# Tallawong Station Precinct South

Response to Submissions: Engineering Items

Client: Landcom

17-Oct-2018

INSET 2 - VEHICLE TRACKING - LEFT TURNS
Scale 1:250

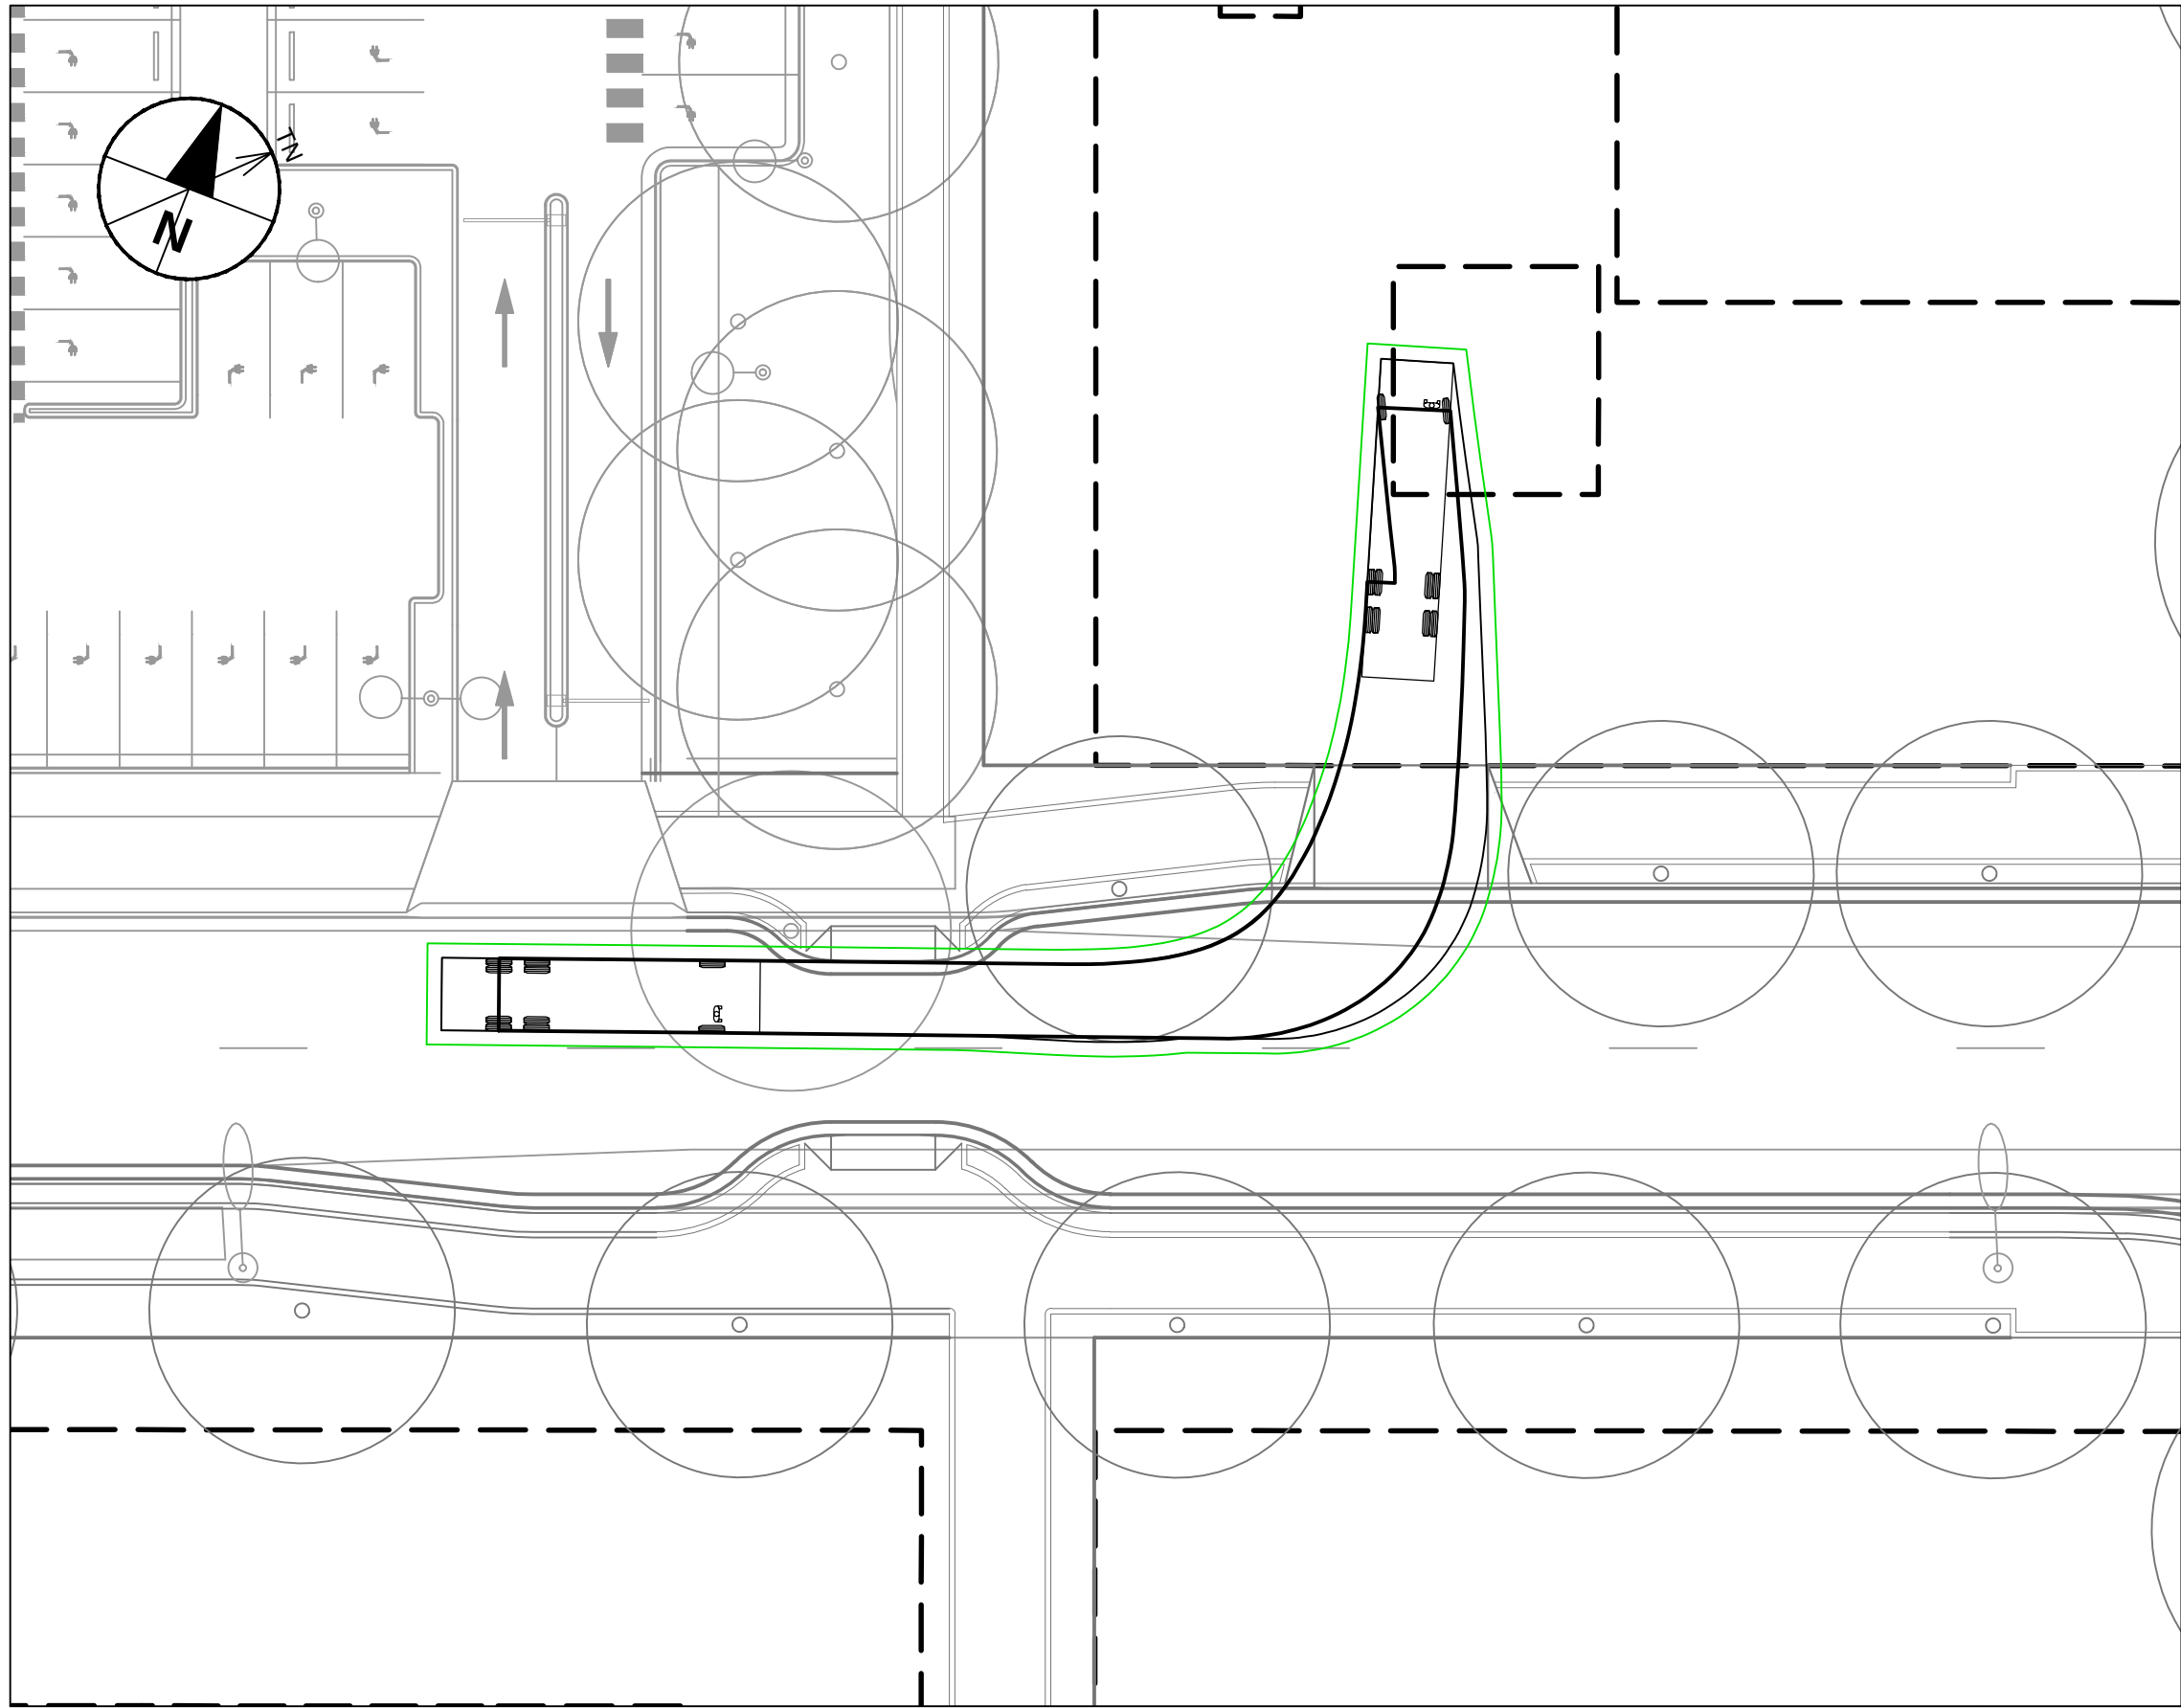
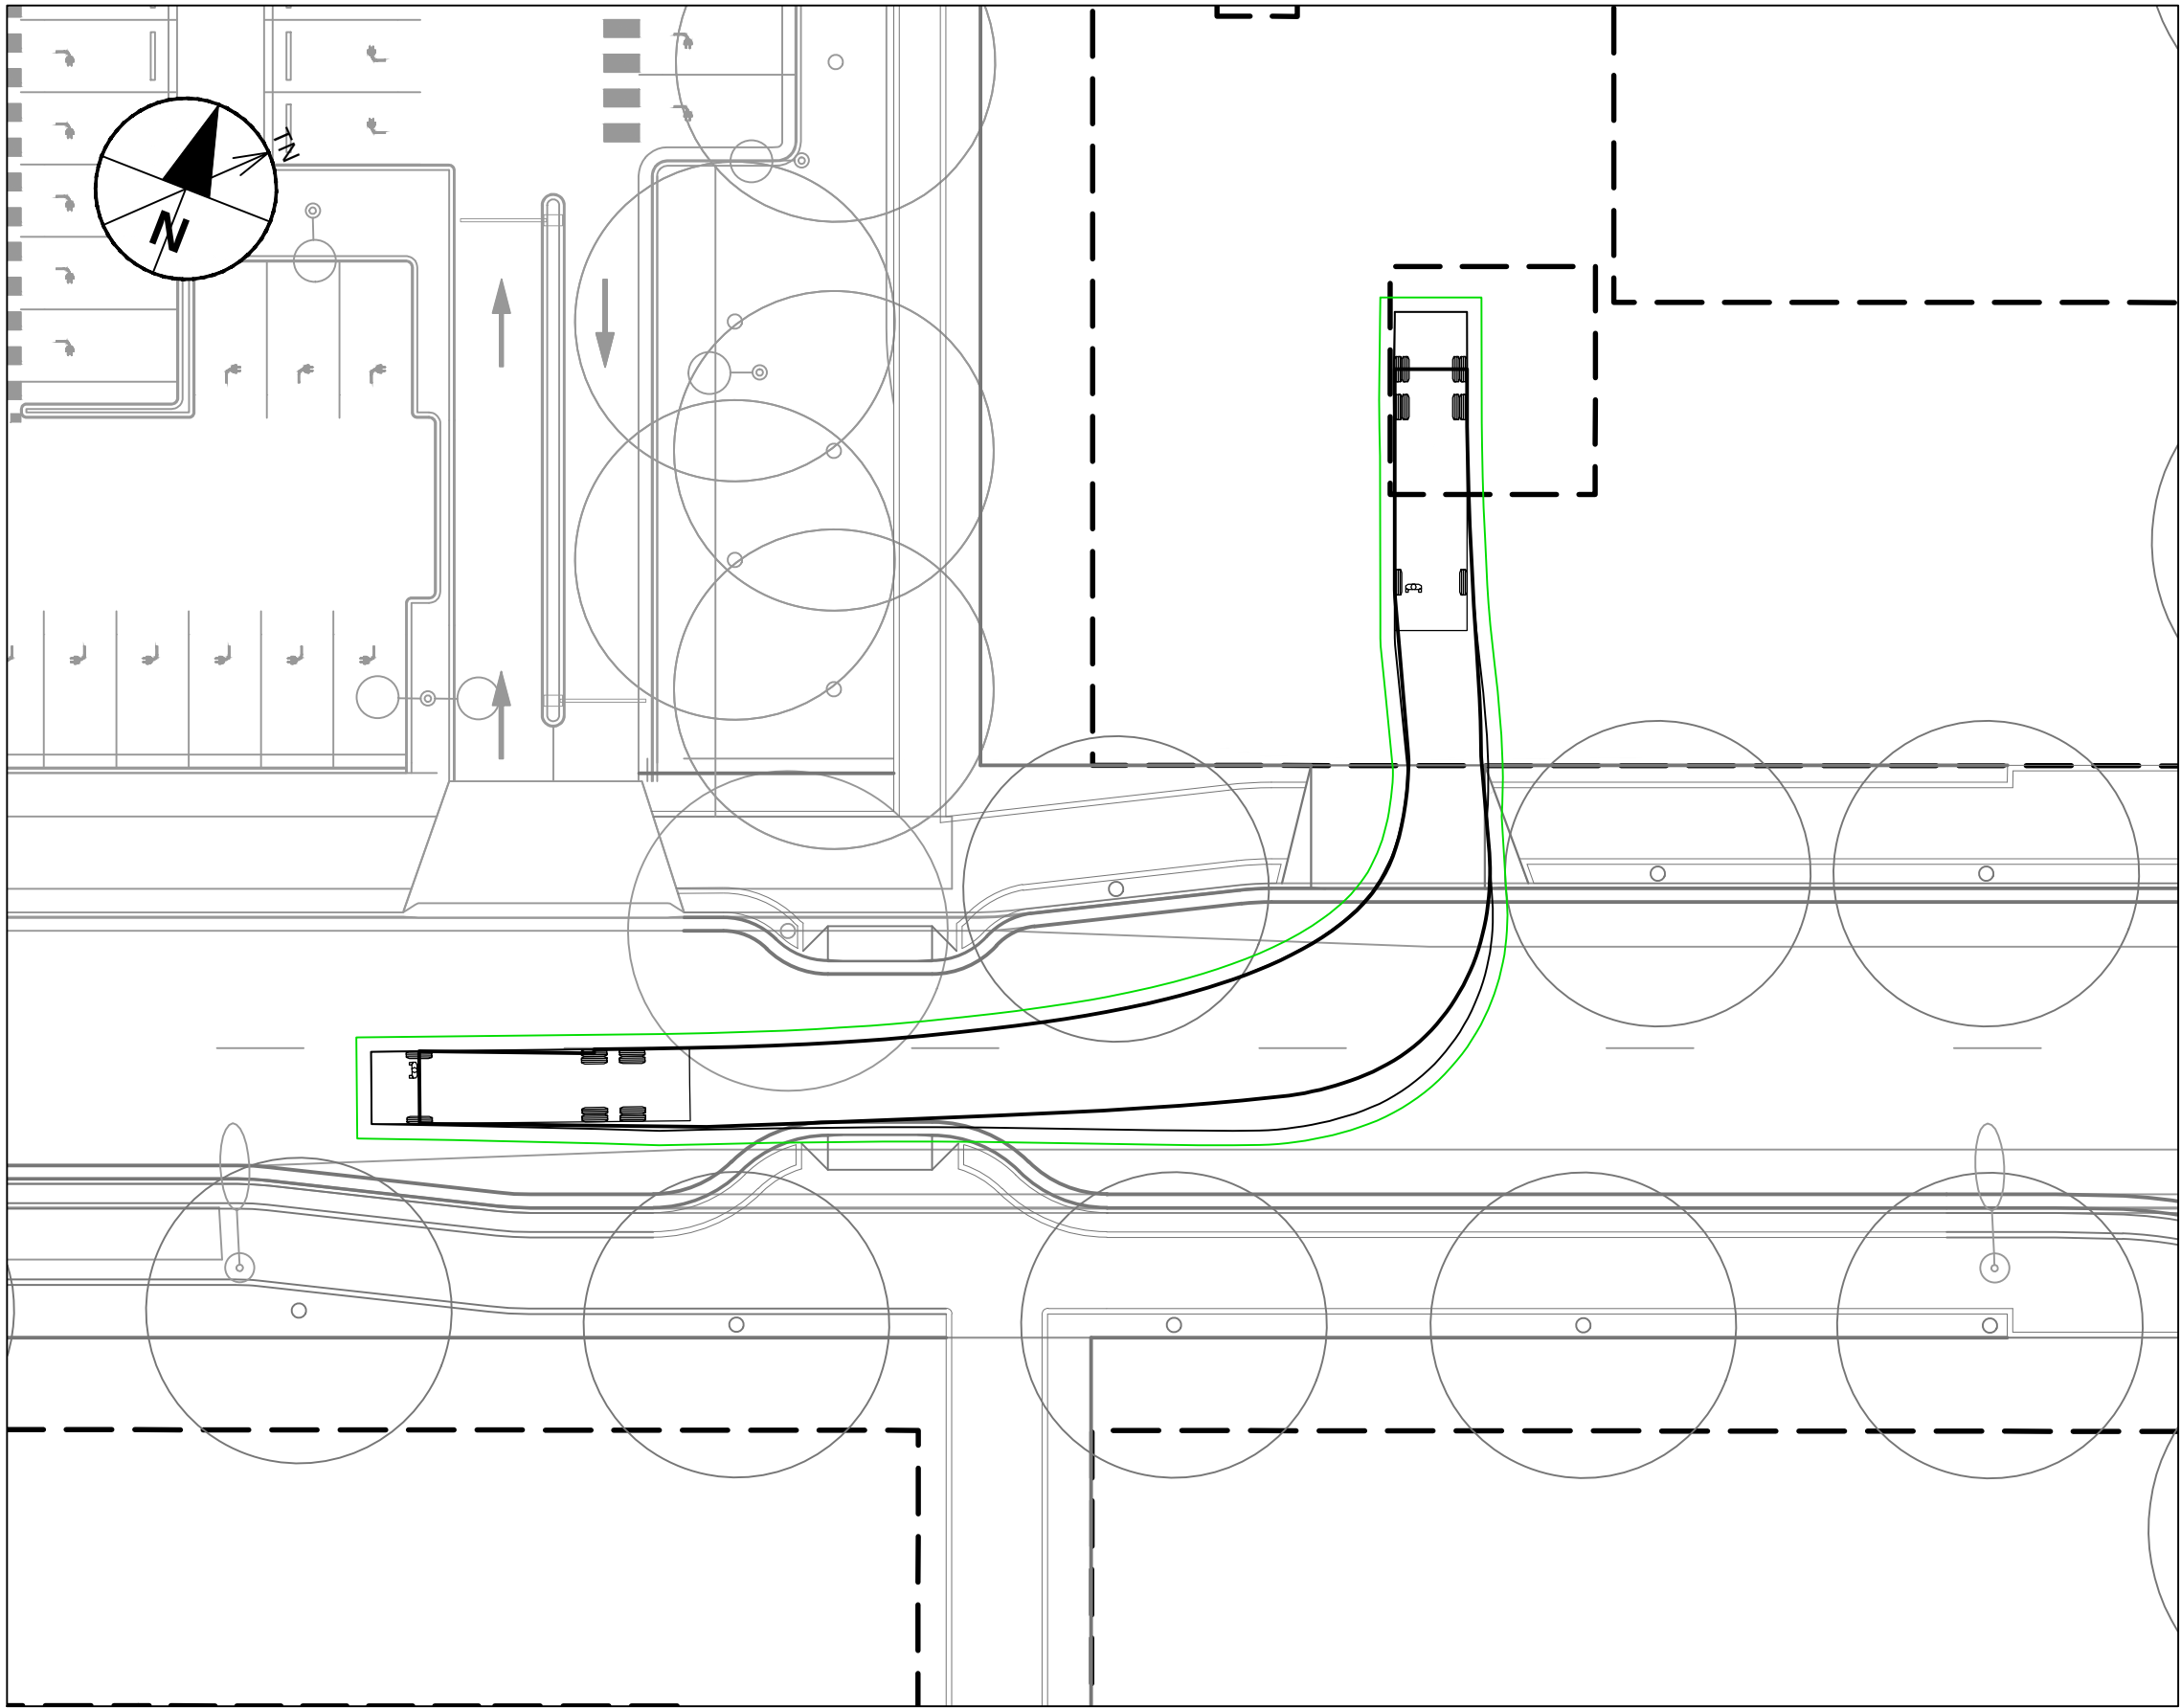
*vi. Demonstrate that the proposed 3.0m lane widths are adequate for larger vehicles such as buses, refuse and service vehicles*

These tracking plans demonstrate that the proposed 3.0m lane widths are adequate for larger vehicles such as buses, refuse and service vehicles.
